CITY OF ALBUQUERQUE

**Re: Rice/McGonagil Residence Grading and Drainage Plan
Engineer's Stamp Date 02/20/2012 (E14/D007)**

sheet title	GRADING & DRAINAGE PLAN
-------------	-------------------------

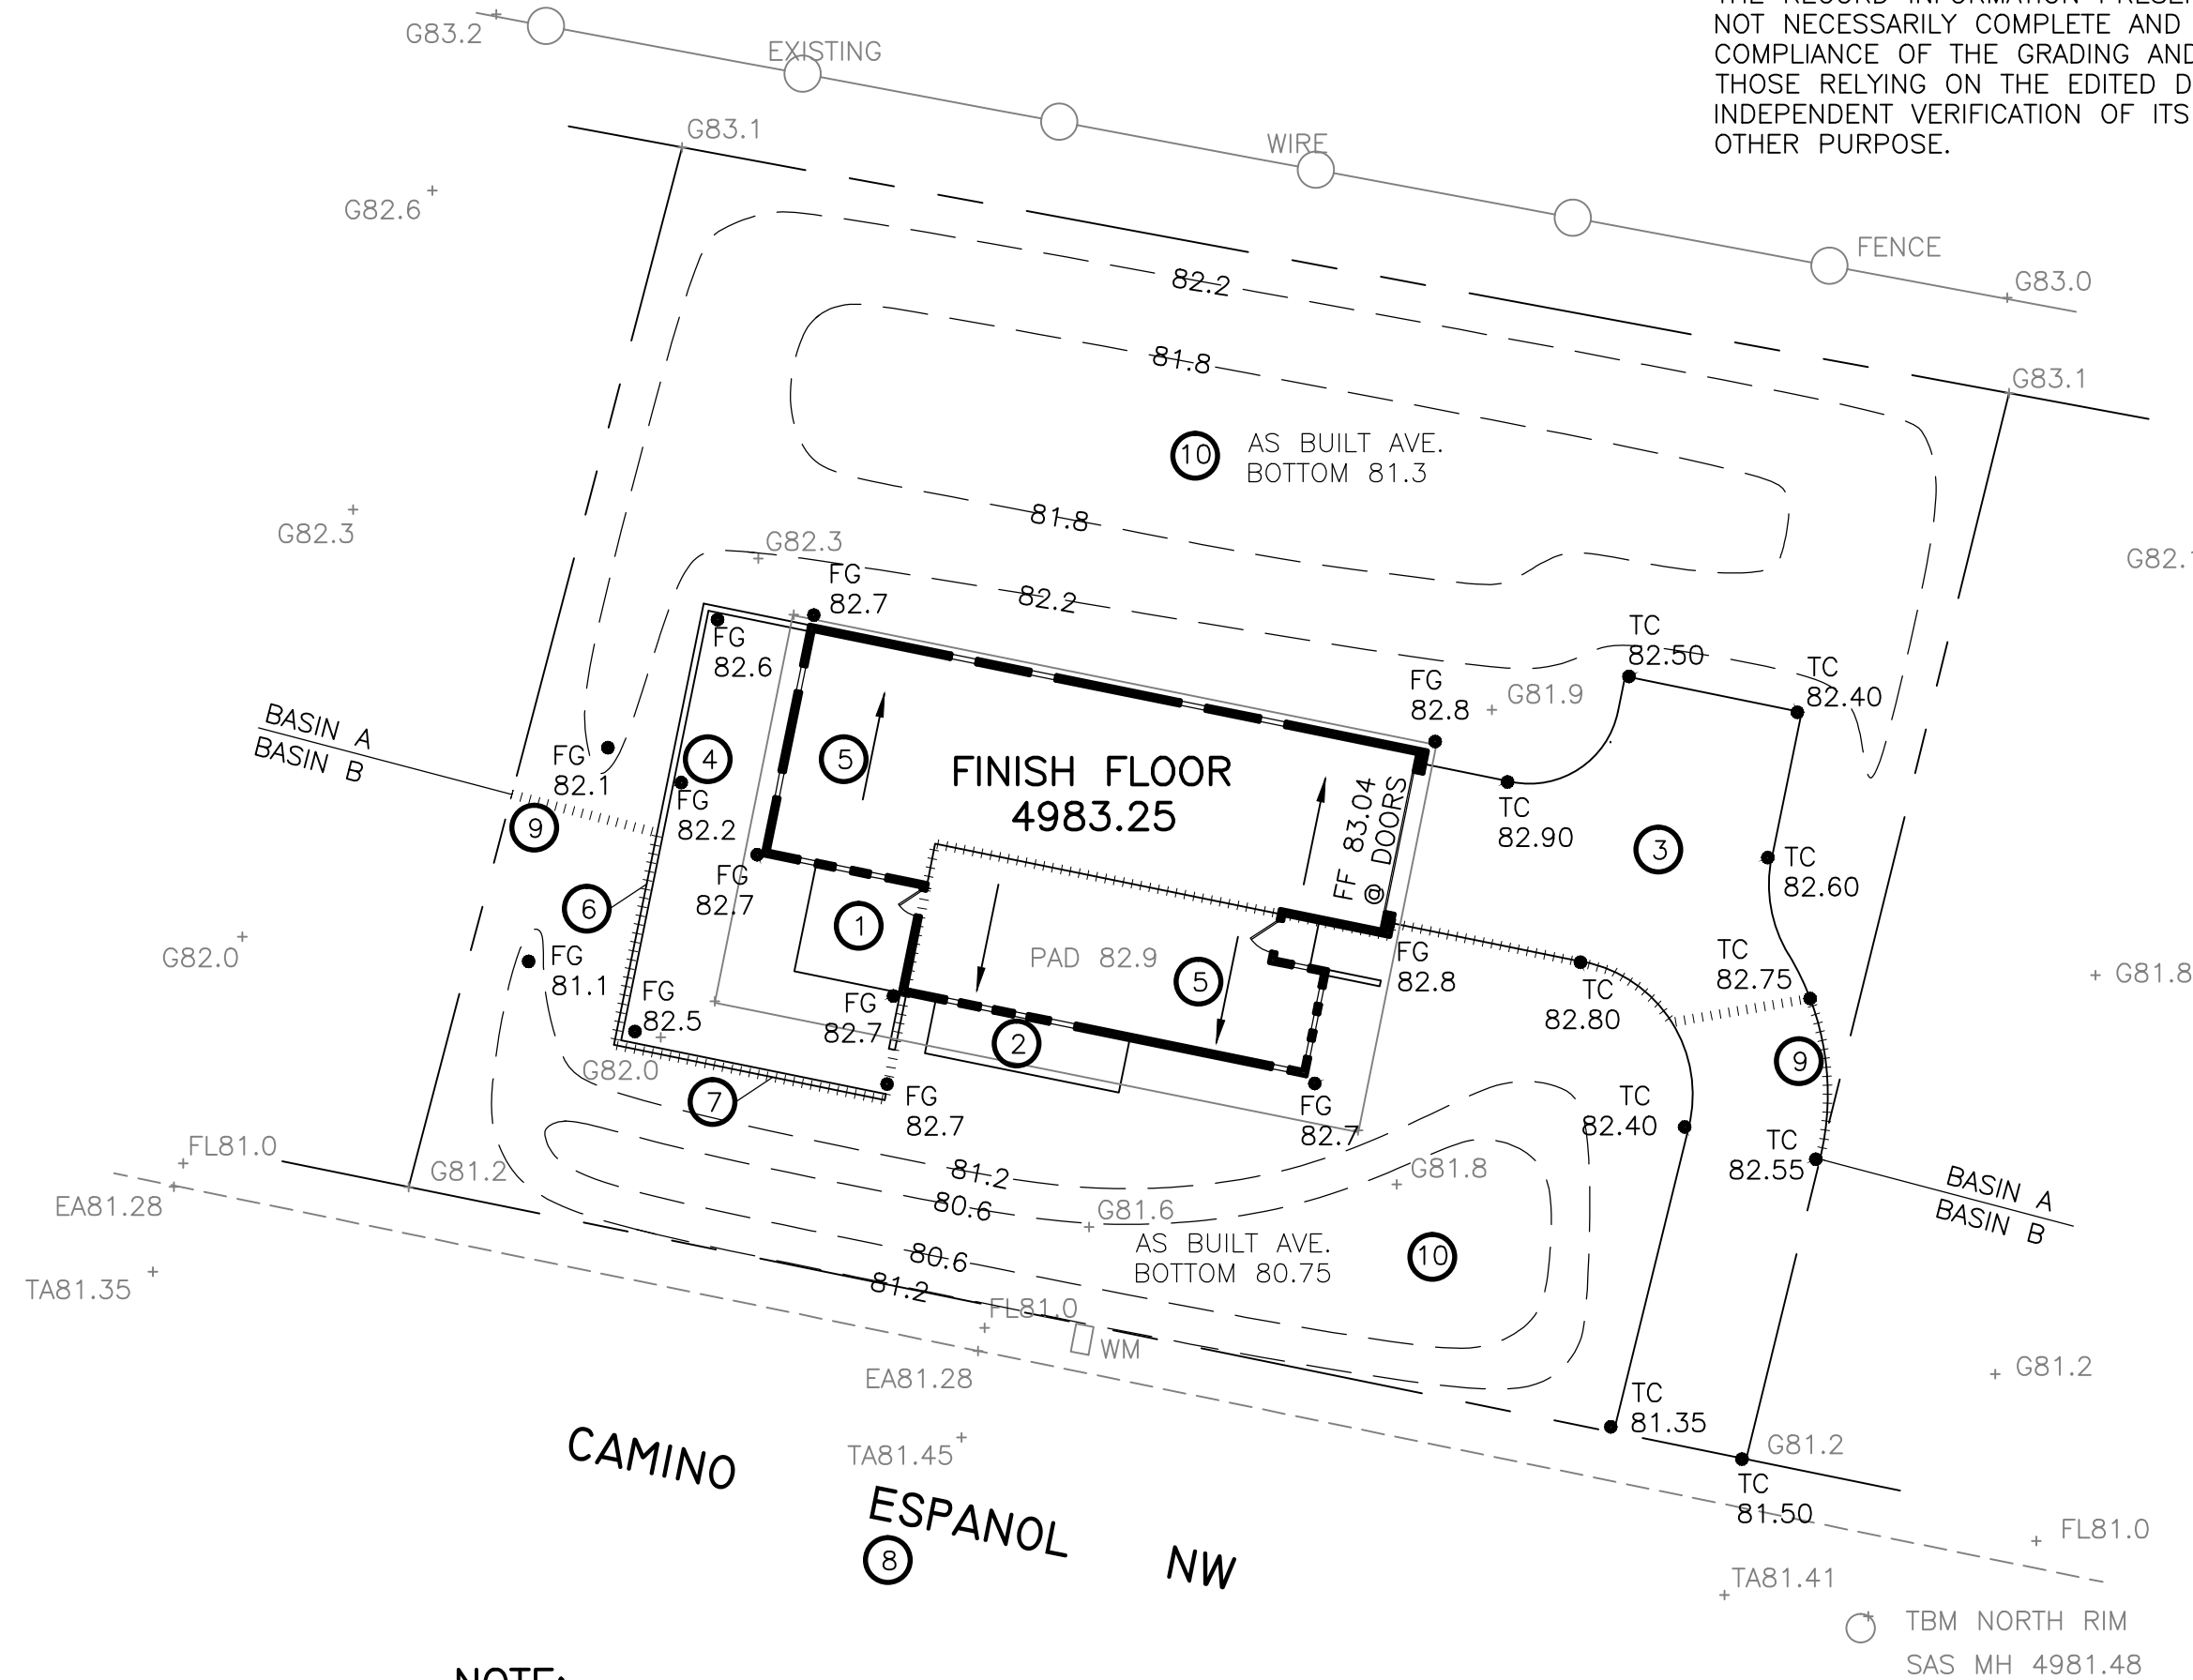
- Street names on the Vicinity Map are not clear. Please mark the location of the site on the Vicinity Map.
- Call out wall openings for the proposed wall on the west side of the building.

- Basin B top of pond is 82.3 under the volume calculations and on the plan view is 82.20.
- Provide proposed grades in front of the garage (+/- 82.75'). Top of concrete just east of the garage is at 82.90. Therefore, the runoff appear to be draining towards the garage.

- Note 3 should be used instead of Note 6 for the proposed driveway.
- Total area under the proposed conditions is more that existing conditions.
- Provide 10 year/6 hour volume calculations under proposed conditions. Volume increase appears to be more than what is called under the "GRADING NOTES".

- Need to lower top of Basin B Pond to allow the runoff from the street enter the pond. Bottom of the pond had two different elevations (80.70 & 81.00).

- Clearly show the limits of Basin A and B.
